Demolition of existing dwelling (No. 32) & erection of 4 No. 4 bed dwellings, alterations to existing dwelling (No. 34A) with alterations to two existing accesses to form a single point of access. This application may affect the Ferring Conservation Area.

32 & 34A Sea Lane Ferring

Ferring Conservation Group objects to this application on the following grounds:

DRAWING TITLE
Proposed Site Plan, Location Plan
and elevation from south

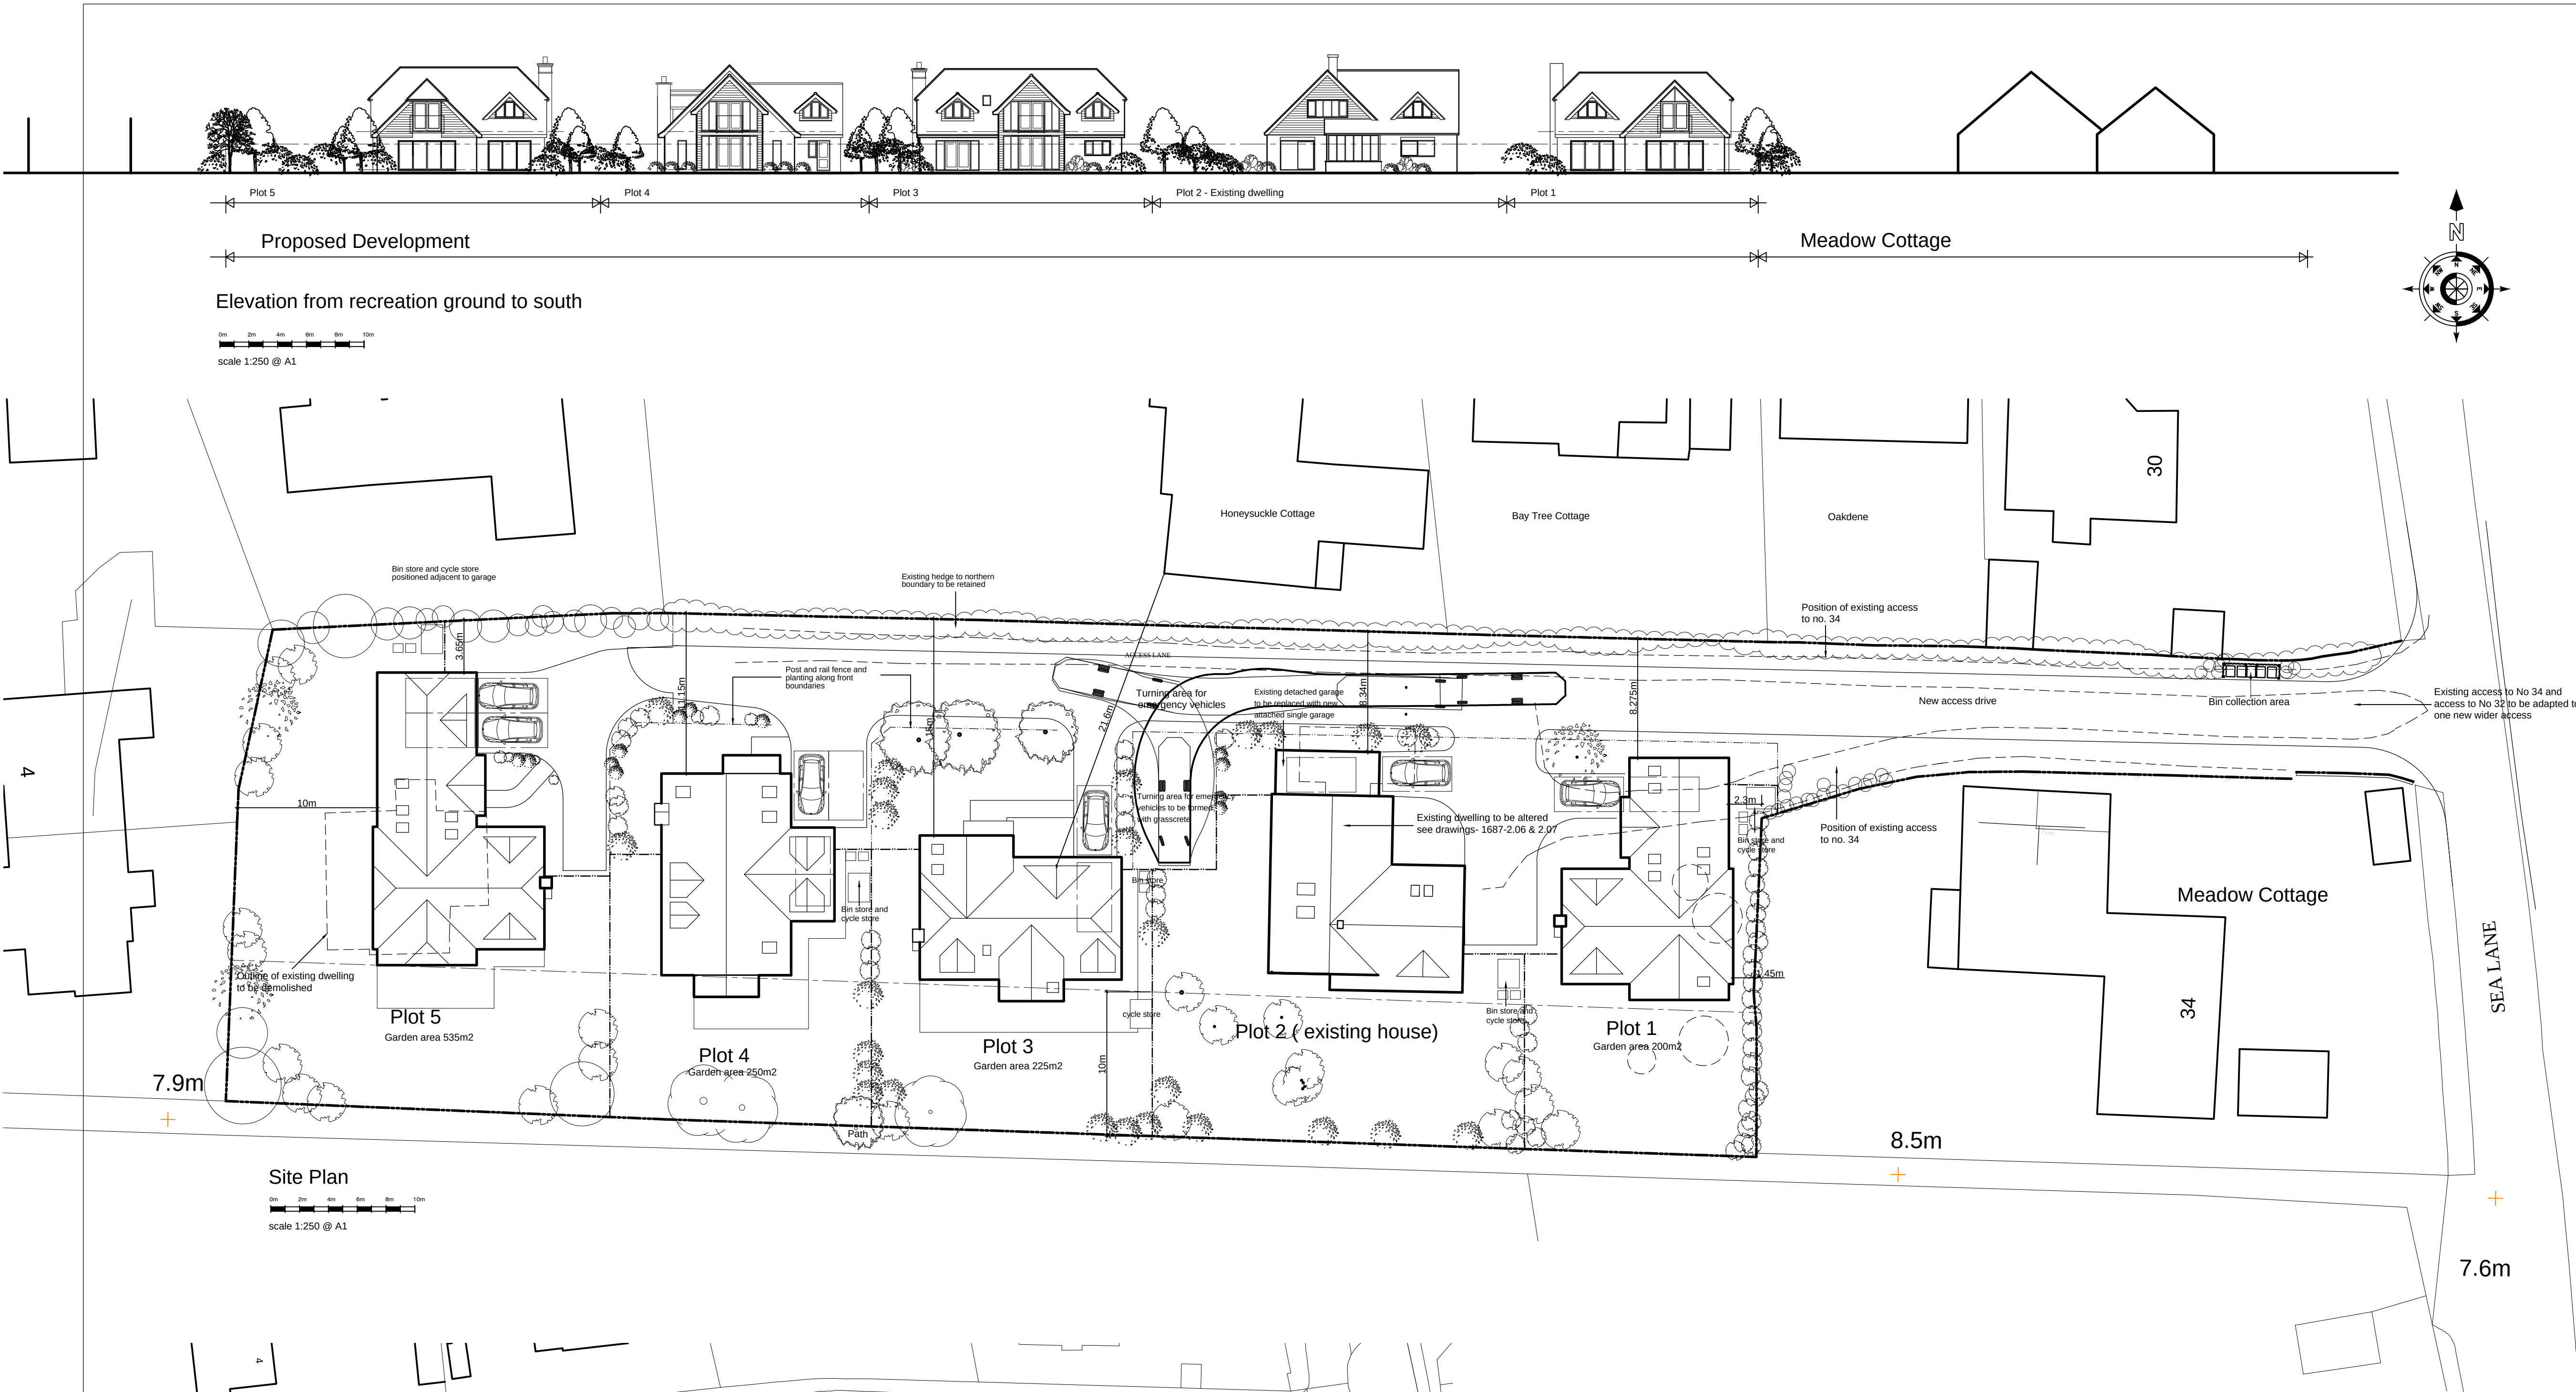
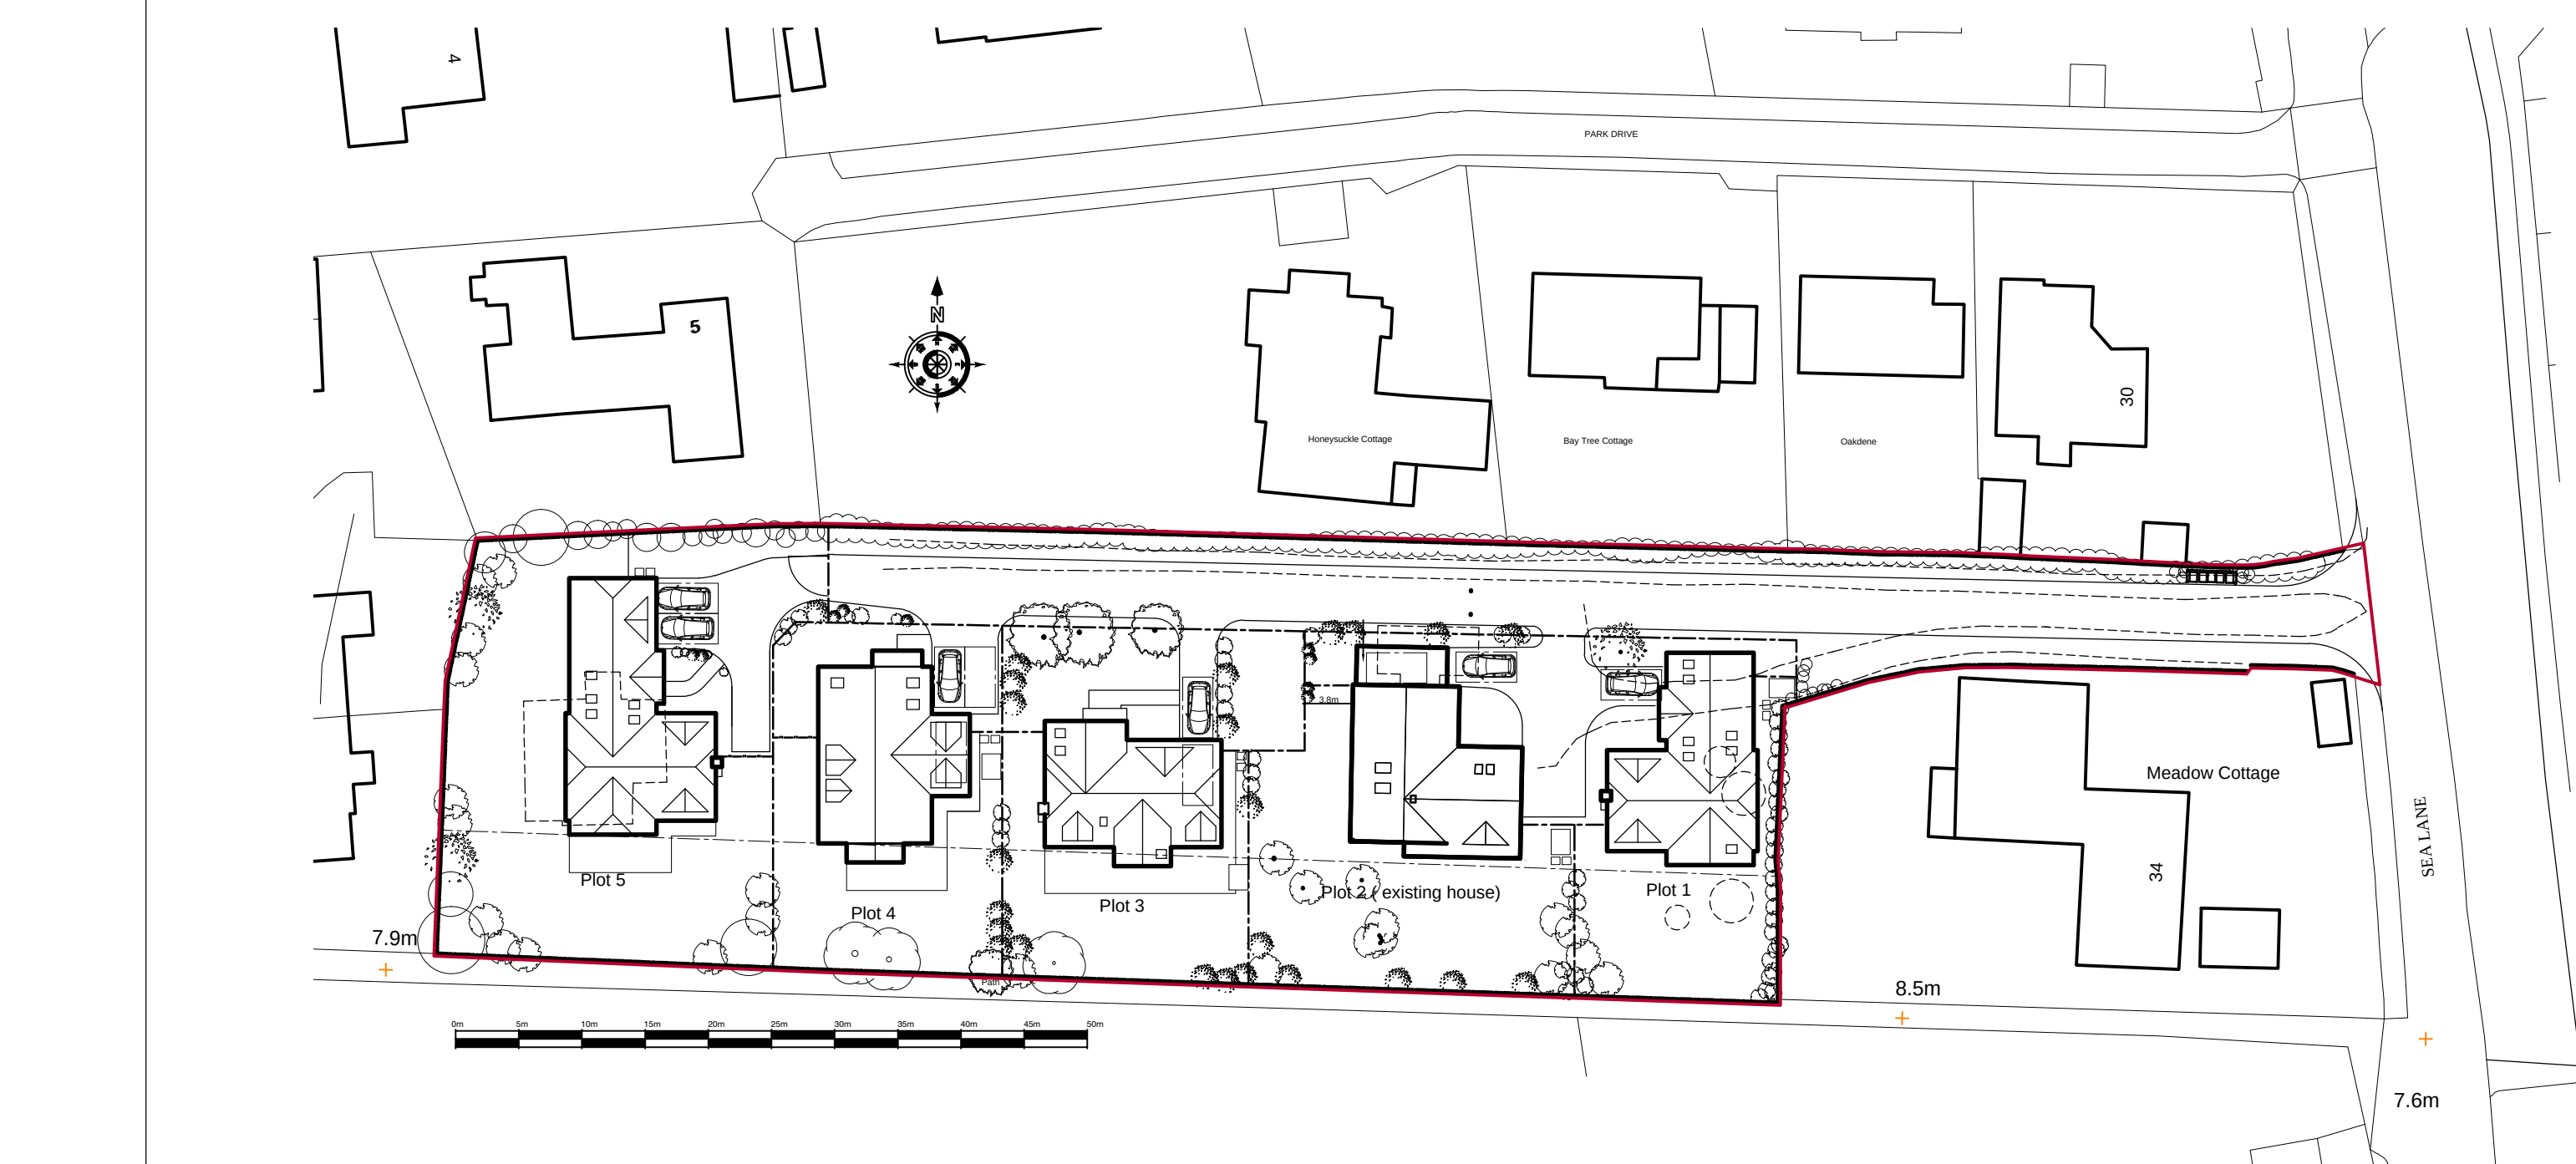
- 1. This is overdevelopment of the site - five houses where there has been two - resulting in a cramped layout and insufficient back garden areas*
- 2. Road safety - the vehicles from five houses entering and exiting the site at the junction with Sea Lane will create hazards for drivers using Sea Lane and for pedestrians, in particular the children attending Ferring Primary School a little further up the lane.*
- 3. Out of character - houses on this side of Sea Lane are on good-sized plots, and while the occupiers of the new properties will have a very good view of Little Twitten Recreation Ground to the south, those using the Recreation Ground will see houses where once there were trees - Ed Miller (Secretary), Ferring Conservation Group*
